STATE OF NORTH CAROLINA  
DEPARTMENT OF TRANSPORTATION

March 22, 2013

**Subject:** Request for Modifications to the Section 404 Individual Permit and Section 401 Water Quality Certification for I-485 (Charlotte Outer Loop) from east of I-77 to I-85 in Mecklenburg County. Division 10, TIP's R-2248 E and R-2123 CE, Debit \$570 from WBS 34410.3.GV2

**Reference:** USACE Individual Permit Action ID SAW-2011-01237, dated Nov.22, 2011.  
NCDWQ Water Quality Certification No. 003868, dated October 14, 2011.  
NCDOT Modification Application dated June 4,2012  
NCDWQ Water Quality Certification Modification dated Jun 21, 2012

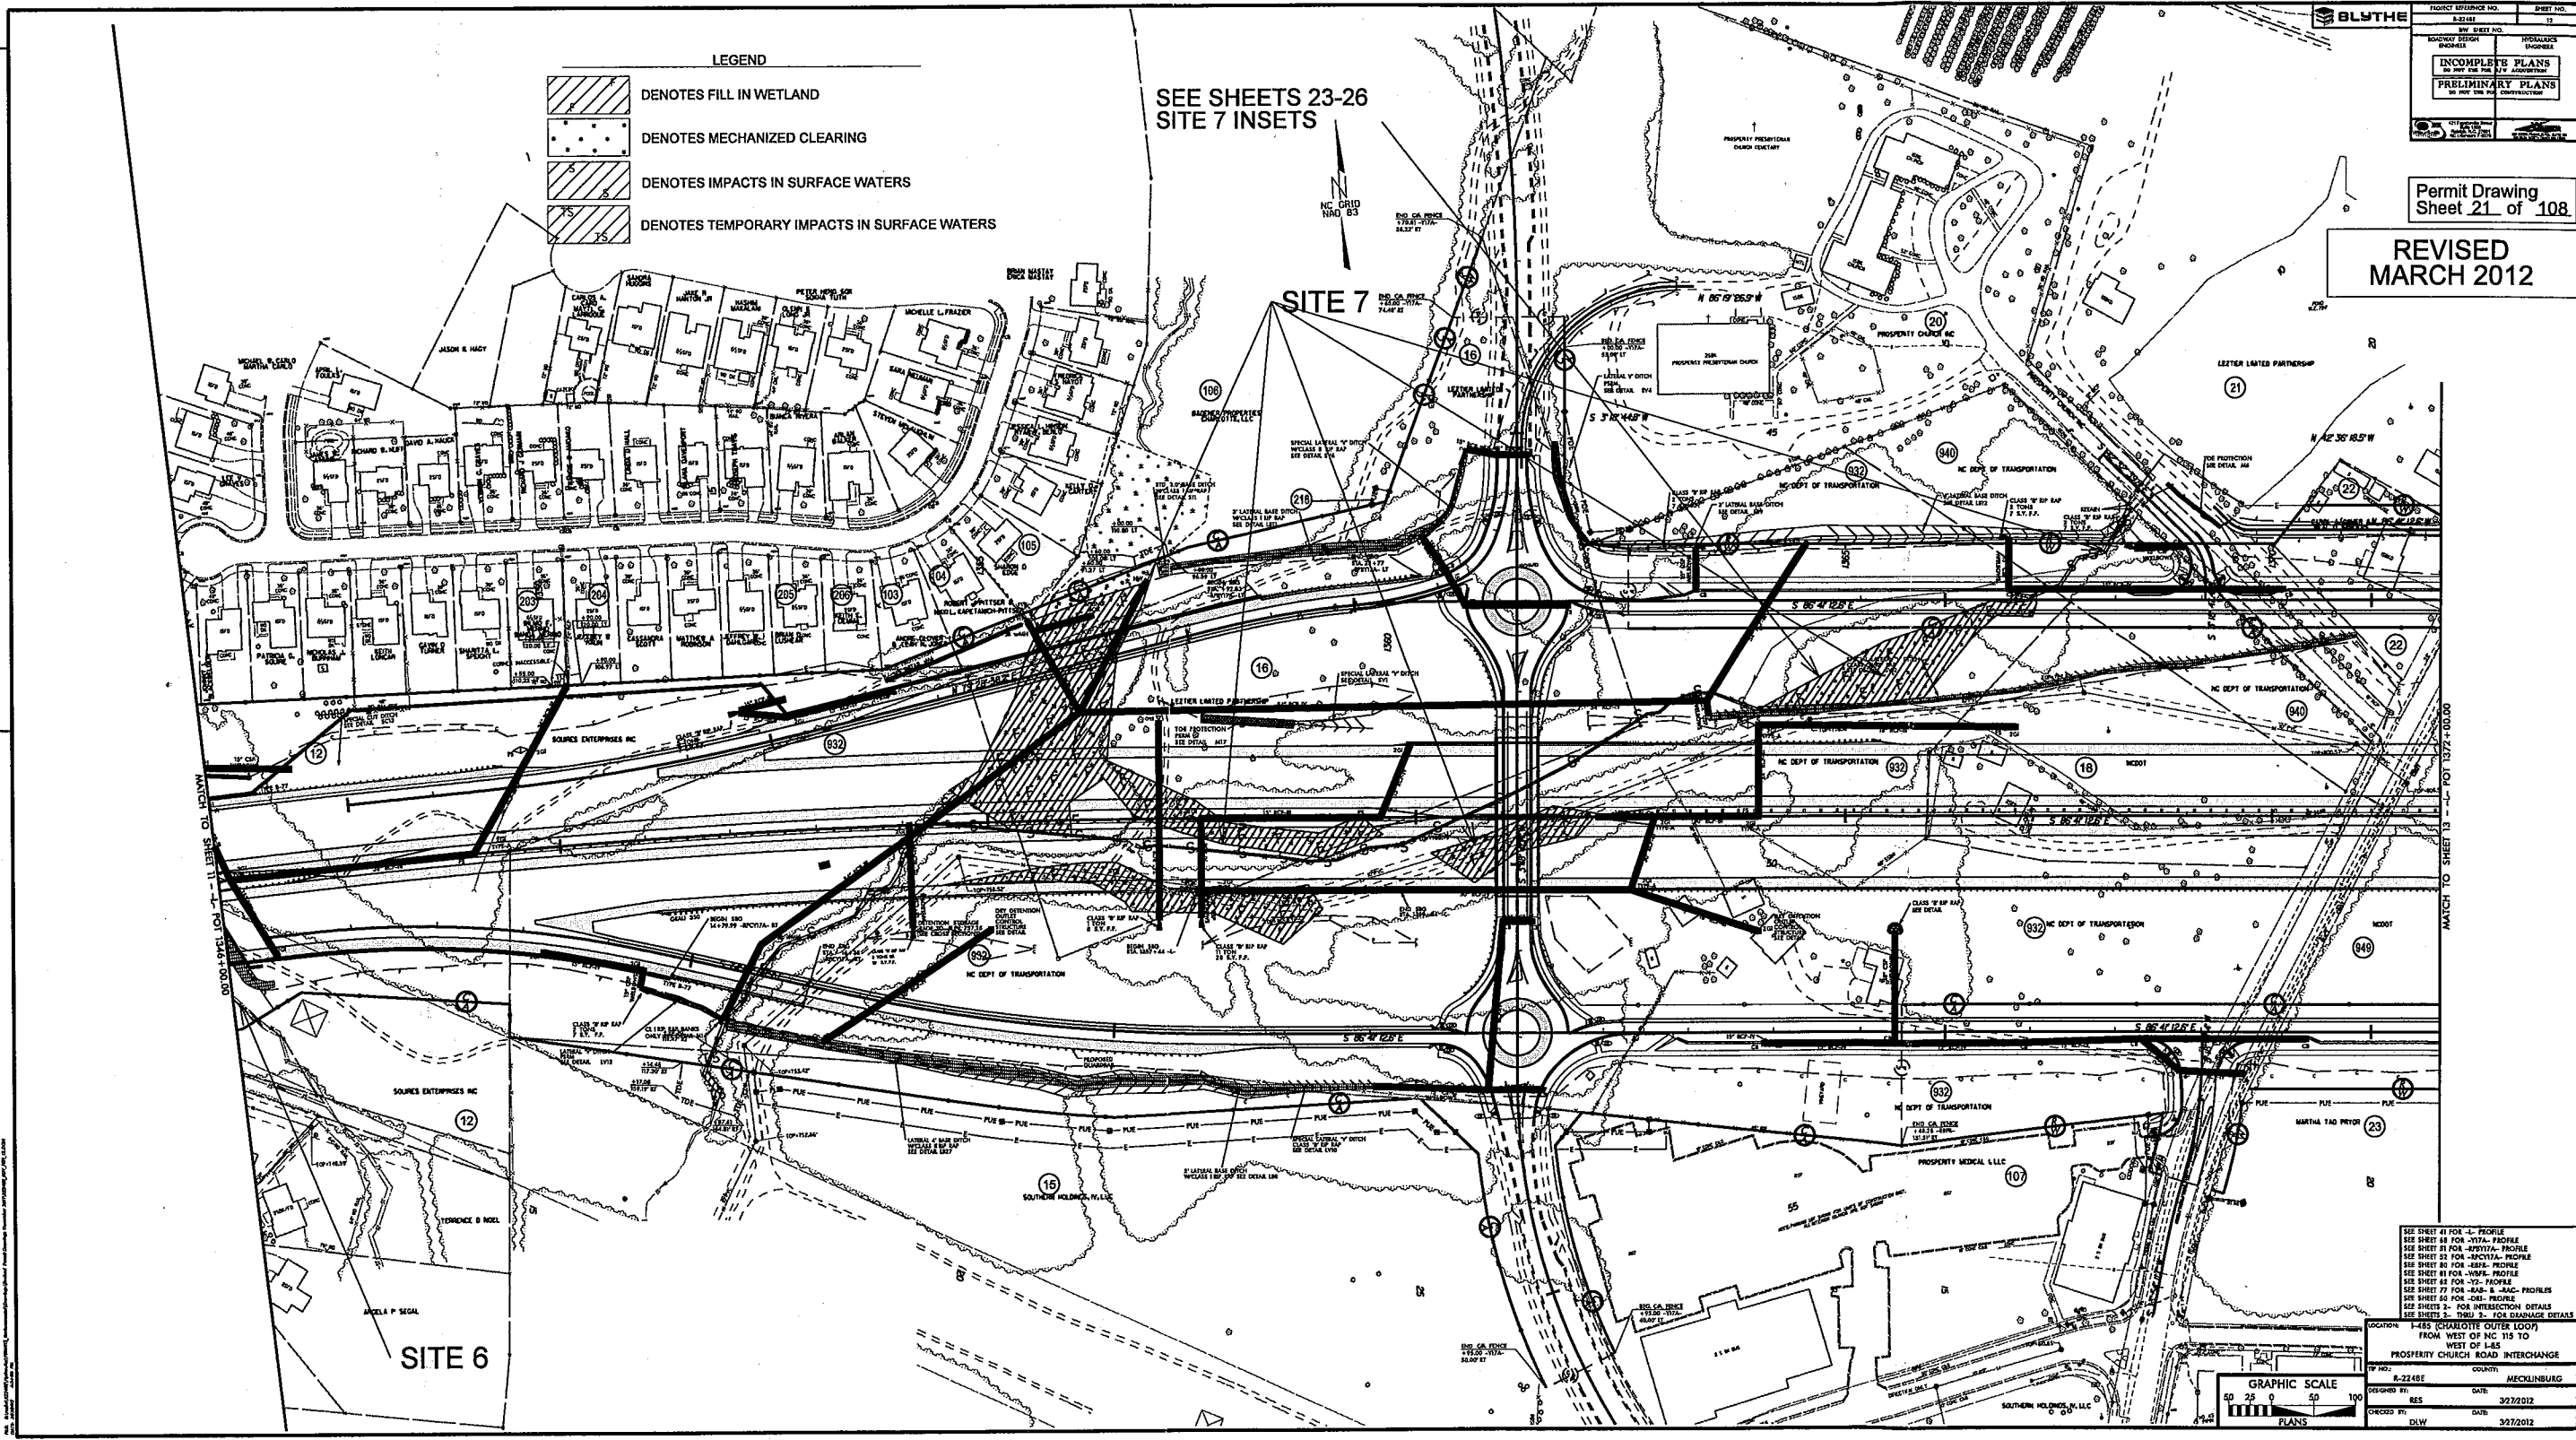
**Revision:** Length of 8' x 7' RCBC increased from 489 to 525 linear feet. (+36 linear feet)  
Bank Stabilization (BS) has decreased from 56 to 44 linear feet. (-12 linear feet BS)  
Temporary stream impacts have decreased from 184 to 175 linear feet (-9 linear feet)

**Reason:** The 8' x 7' RCBC was lengthened and slightly shifted to the south. Minor grade, fill slope, and alignment changes were necessary to accommodate the approach to the new bridge over Stream S7.

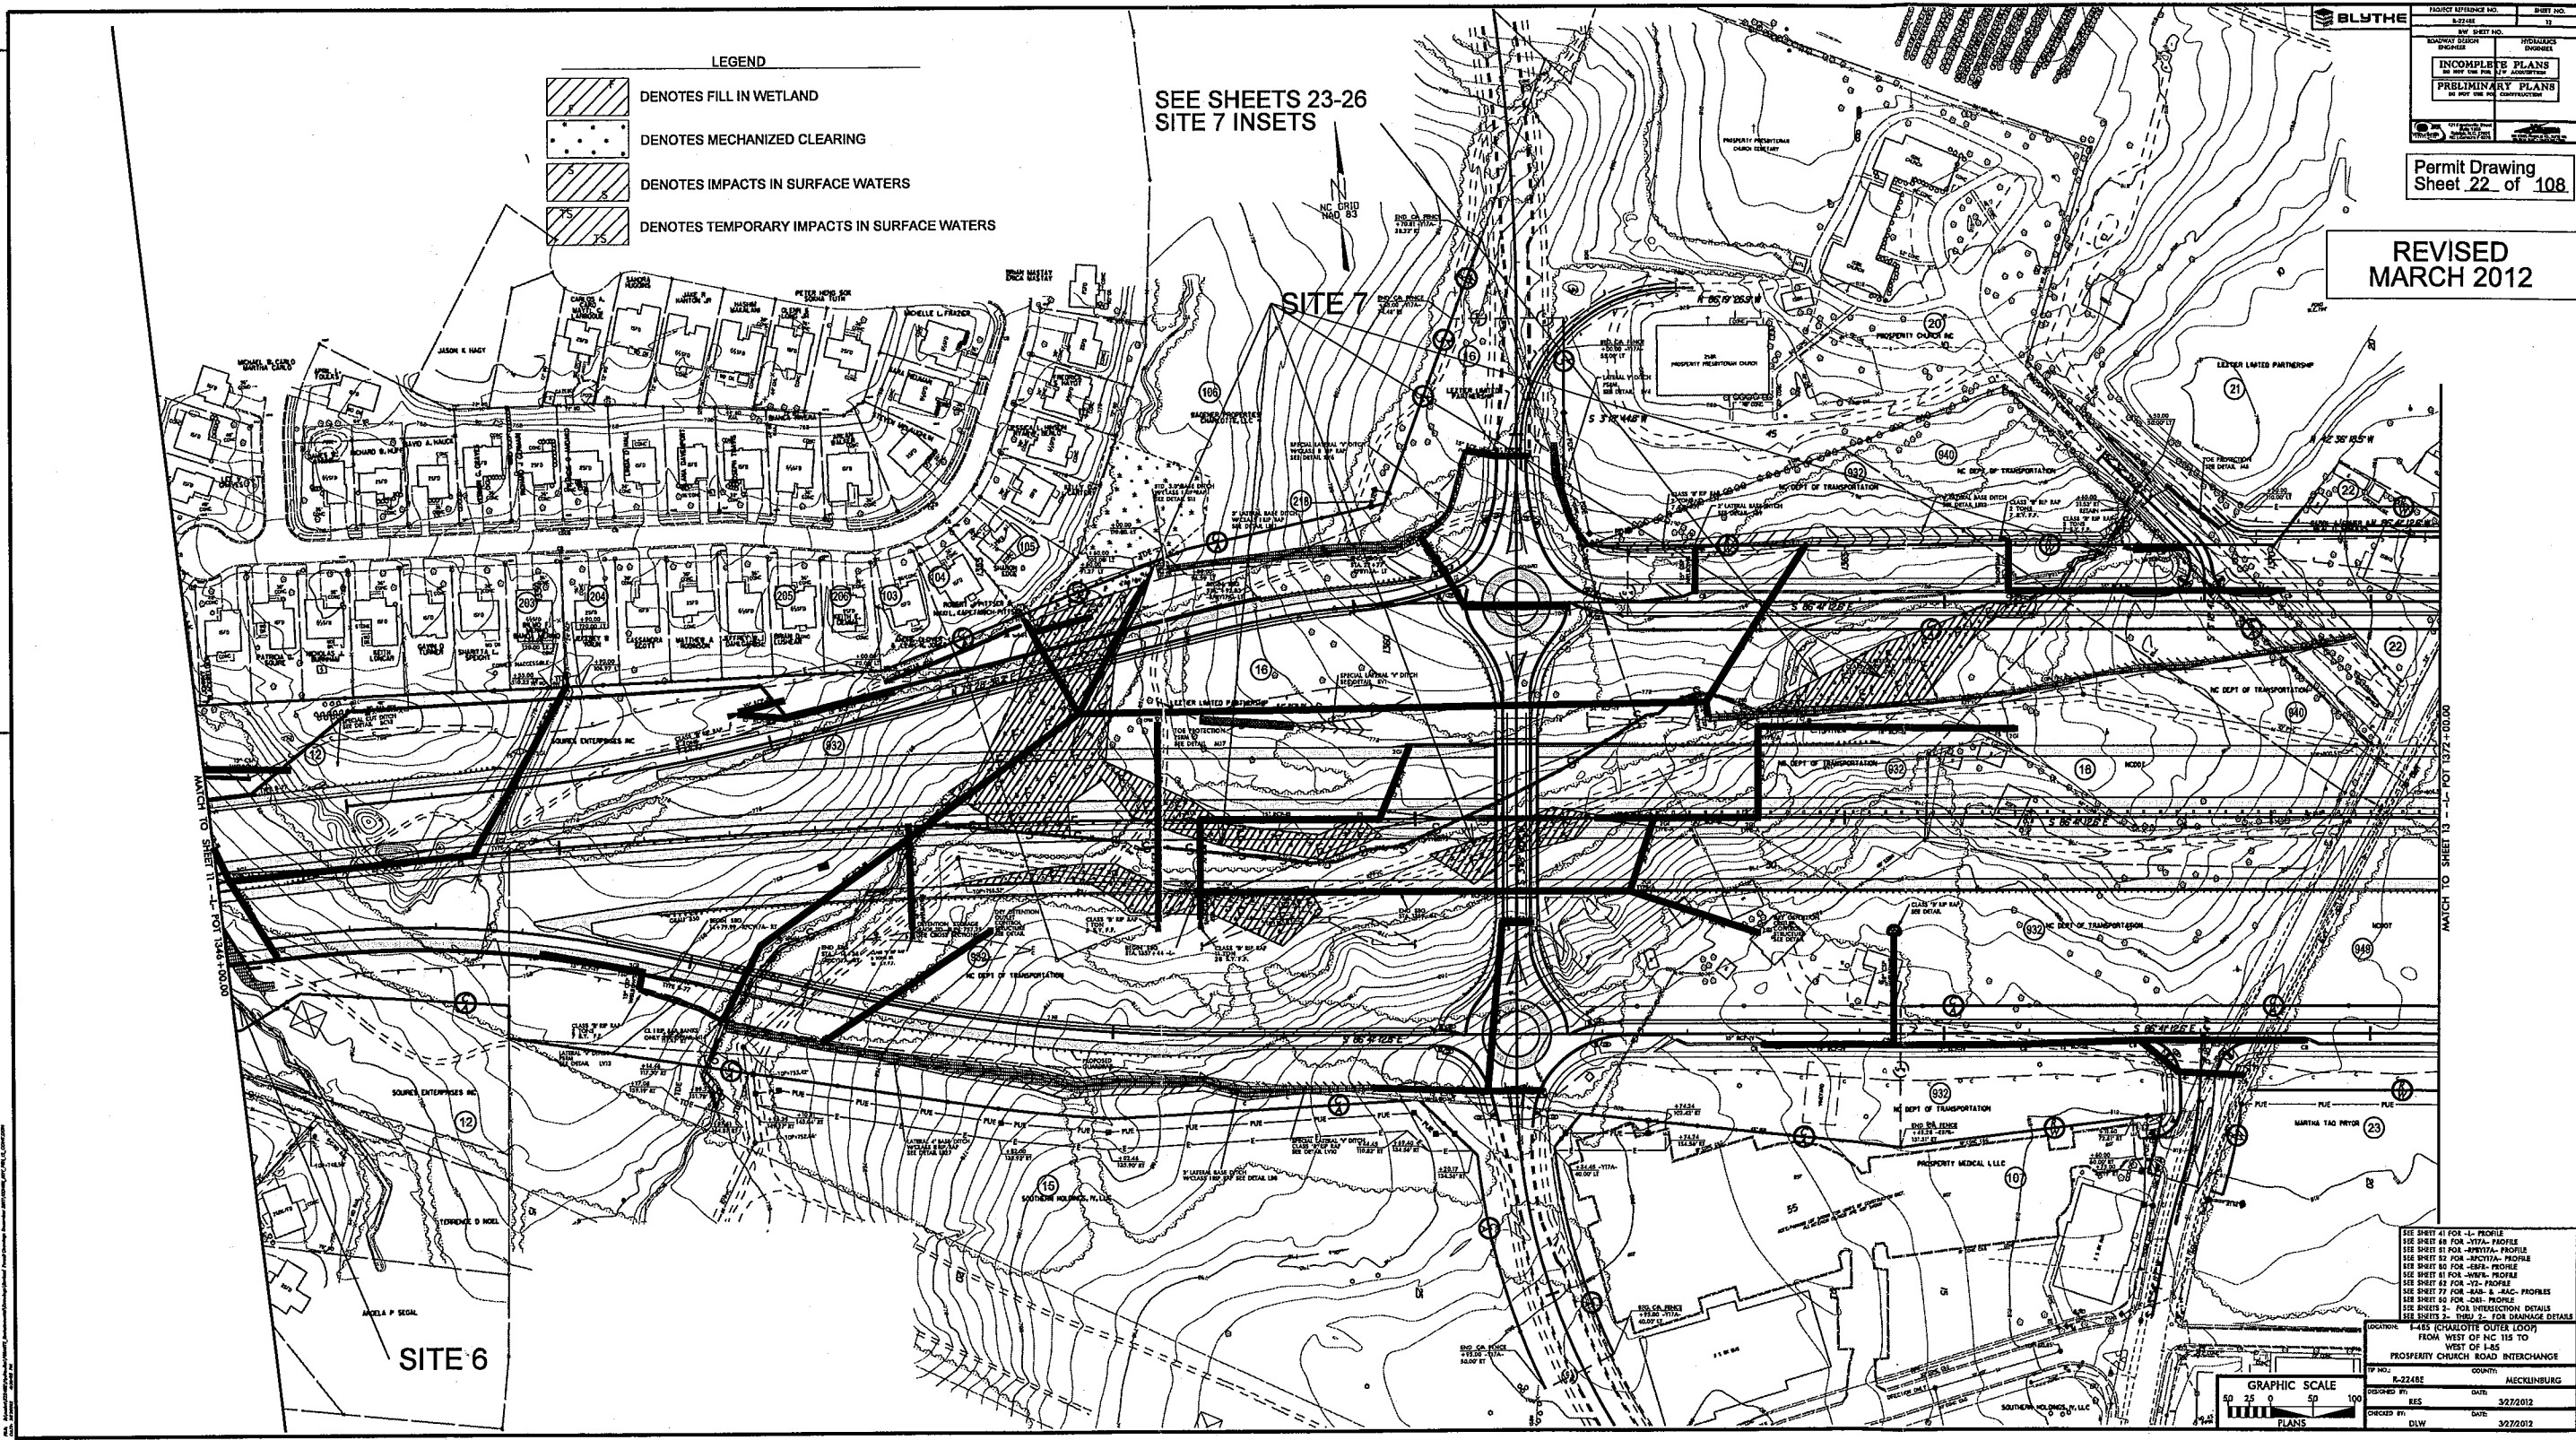
**Revision:** Elimination of 9' x 7' RCBC at Site 6 (-276 linear feet)  
Elimination of BS impacts at Site 6 (-36 linear feet BS)  
Temporary impacts have decreased from 96 linear feet to 0 (-96 linear feet)

**Reason:** Dual bridges will be constructed to cross the area including Stream S7.
